**KIRKLEES METROPOLITAN COUNCIL
INVESTMENT & REGENERATION SERVICE**

**DELEGATED DECISION FOR APPLICATION FOR CERTIFICATE OF
LAWFUL DEVELOPMENT**

Reference no.: 2025/CL/92315/W

Description: Certificate of lawfulness for proposed extension to
integral garage

title Garage as proposed  
number 25057D-03-P02  
scale 1:100, 1:1250  
size A1

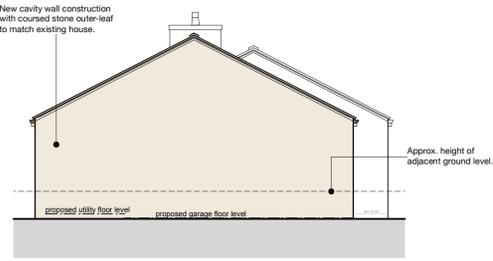
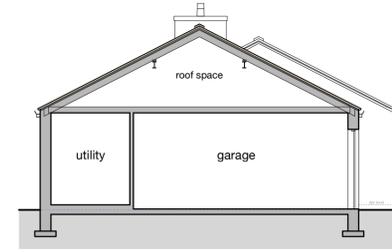
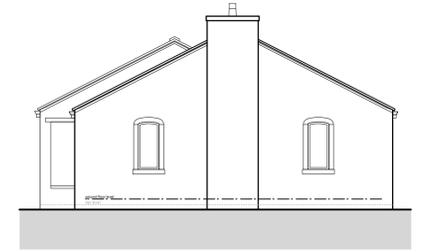
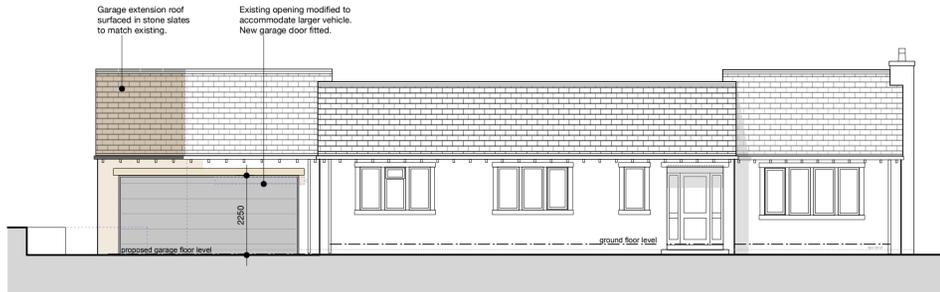
The extension would project from the side elevation of the property by 2.5 metres and would lie flush with the existing front and rear elevations of the part of the dwellinghouse it would attach to. The eaves height would be 2.75 metres rising to an overall height of 5.2 metres to the ridge of the dual-pitched roof.

Comment: *The enlarged part of the dwellinghouse would extend beyond a wall forming a side elevation of the original dwellinghouse and would exceed 4 metres in height; would not have a single storey and would not have a width greater than half the width of the original dwellinghouse.*

The single storey side extension does not benefit from a general planning permission under Schedule 2, Part 1, Class A of the Town and Country Planning (General Permitted Development) (England) Order 2015 (as amended) as it would be contrary to A.1(j) of the same Order by reason of the height exceeding 4 metres.

site plan

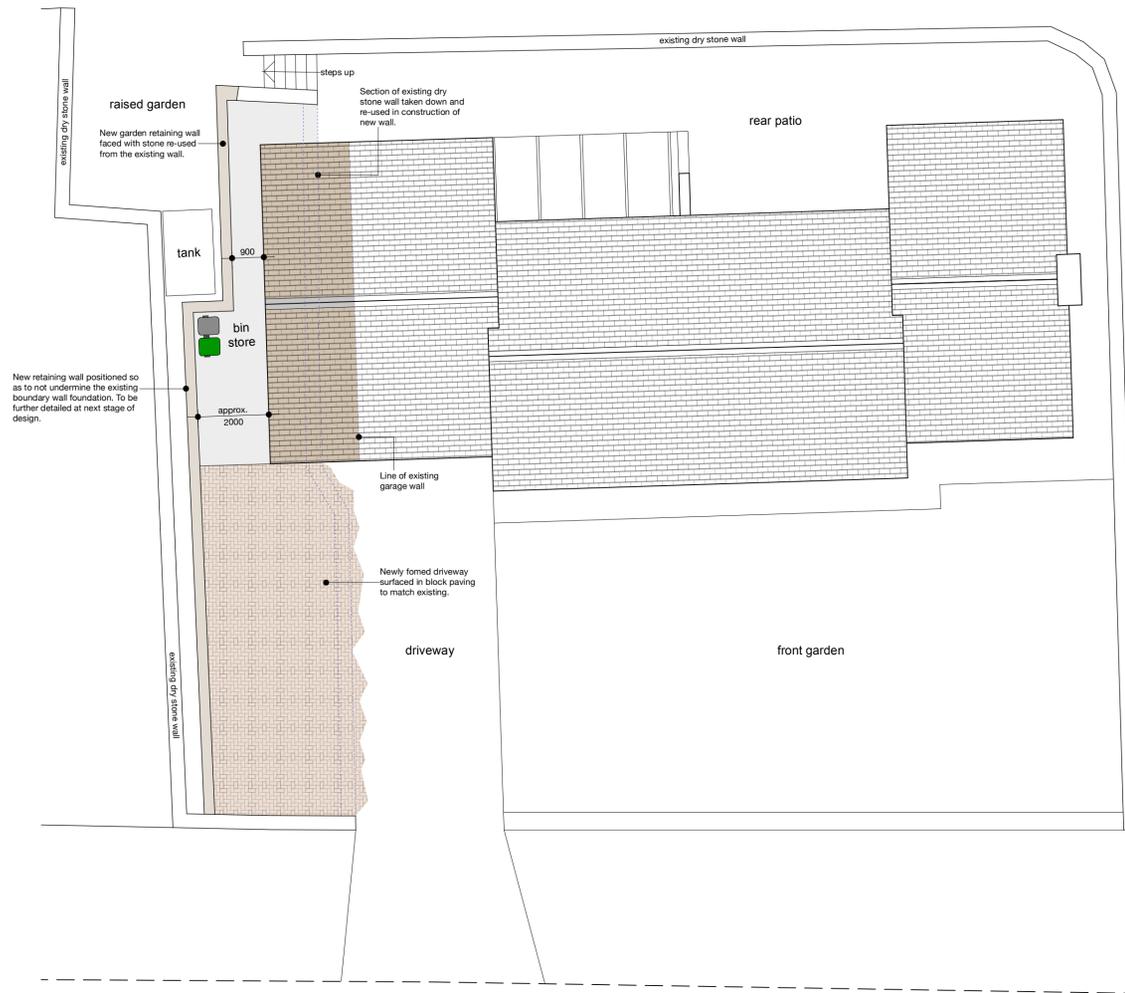
Comment: *The area of ground to be covered by the hard surface exceeds 5 square metres and the proposed new driveway would be surfaced in block paving. The applicant annotates the proposed plan stating the block paving would match the existing. Google Streetview imagery shows the existing driveway to fall towards the highway and as such the water run-off does not drain into the curtilage of the dwellinghouse. The existing block paving appears solid, pointed and on the balance of probability not porous. The applicant has not provided any evidence to demonstrate otherwise.*

The proposed extended driveway does not benefit from a general planning permission under of Article 3(1) and Schedule 2, Part 1, Class F of the Town and Country Planning (General Permitted Development) (England) Order 2015 (as amended) as no evidence is provided to demonstrate the hardsurface will either drain onto land within the curtilage of the dwellinghouse or is constructed from porous material, thus contrary to condition M.2.
